DOC17/88811-1
SSD 7332

Eagleton Quarry - Environmental Impact Statement - Exhibition (SSD 7332)

ATTACHMENT A: OEH REVIEW - EAGLETON QUARRY ENVIRONMENTAL IMPACT STATEMENT EXHIBITION (SSD 7332)

7

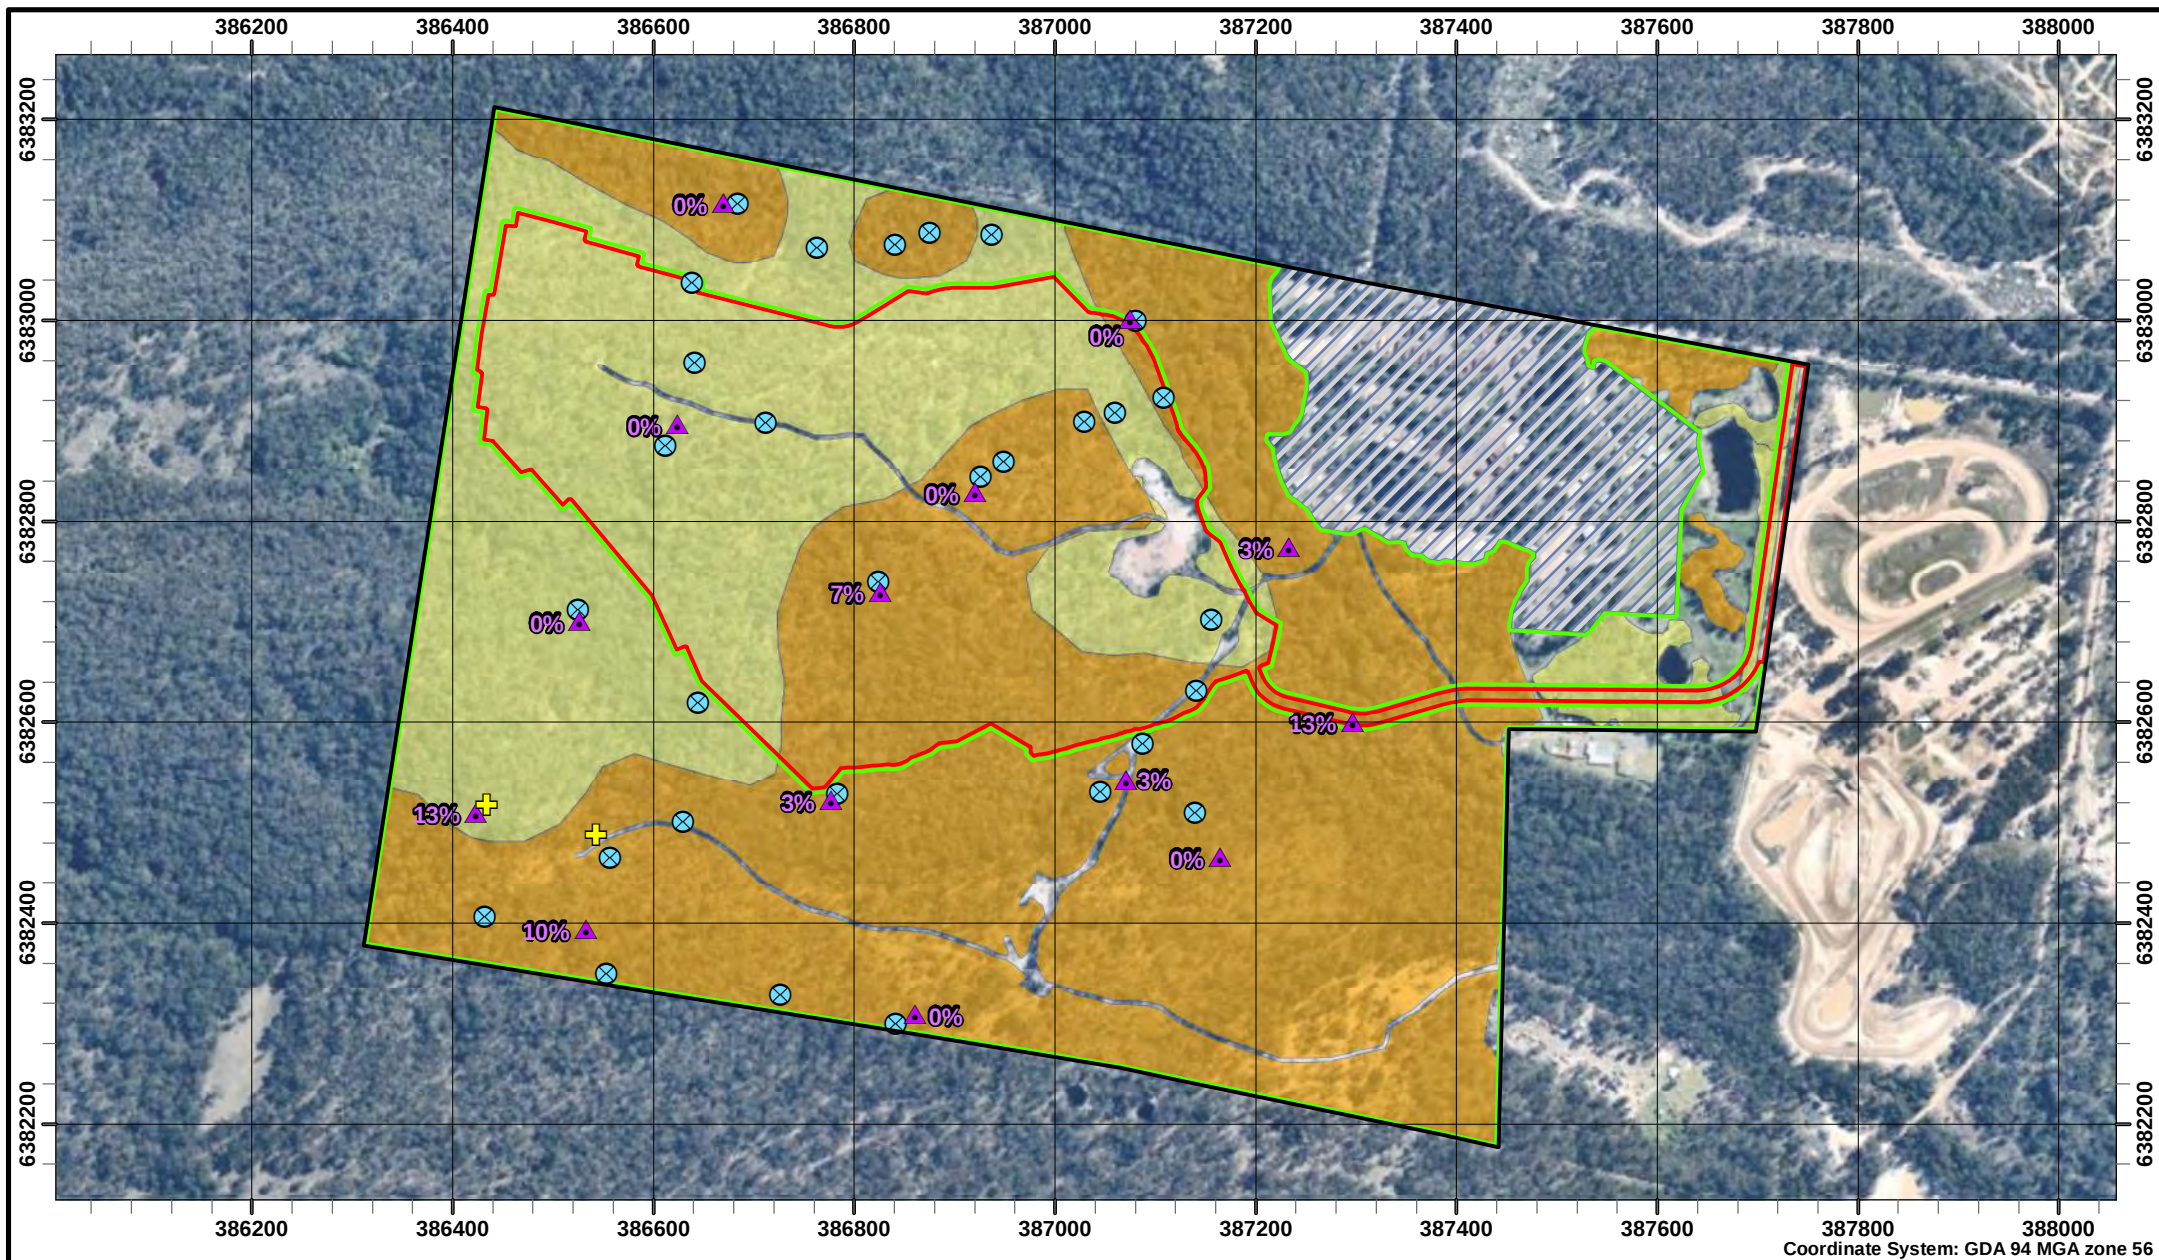
- The BAR indicates that the Koala and the Southern Myotis were recorded on both the development and offset sites. Under BBAM, all suitable habitat (i.e. foraging and/or breeding) for these species must be identified on both sites to determine the 'species' credit yields (i.e. for development sites the number of credits the impact will generate, and similarly for the offset site credits that can be used to offset the impact). OEH generally concurs with the species habitat polygons used to generate the 'species' credits, as schematically shown on the habitat maps in the BAR (Figures 5 [Koala] and 6 [Southern Myotis]). With regard to the Koala, OEH notes that the proponent has utilised the methodology under SEPP44 (Koala Habitat Protection) in identifying areas which have greater than 15% of recognised primary browse / feed trees (e.g. *Eucalyptus punctata* and *Eucalyptus tereticornis*) and then further assessing these areas to determine potential occupancy rates via SAT analysis (Phillips & Callaghan 2011). OEH notes that this has resulted in a much more precautionary map (and ultimately more accurate) than the Port Stephens 'Comprehensive Koala Plan of Management' habitat mapping (as shown in Figure 7 of the BAR), which only identifies small areas of Preferred Koala Habitat within the south-eastern corner and along the southern boundary of the proposed offset areas. OEH supports this approach as it appears to correlate well with areas of suitable habitat that were observed during the site inspection. Nevertheless, OEH questions why SAT Test Location in the far south-eastern corner of the proposed offset area, which recorded a 13% activity level, is not included within the 'Koala habitat area' polygon (as per Figure 8 of the BAR).

OEH recommends that either appropriate justification be given as to why this site was excluded or the boundary of the habitat area be amended to include it.
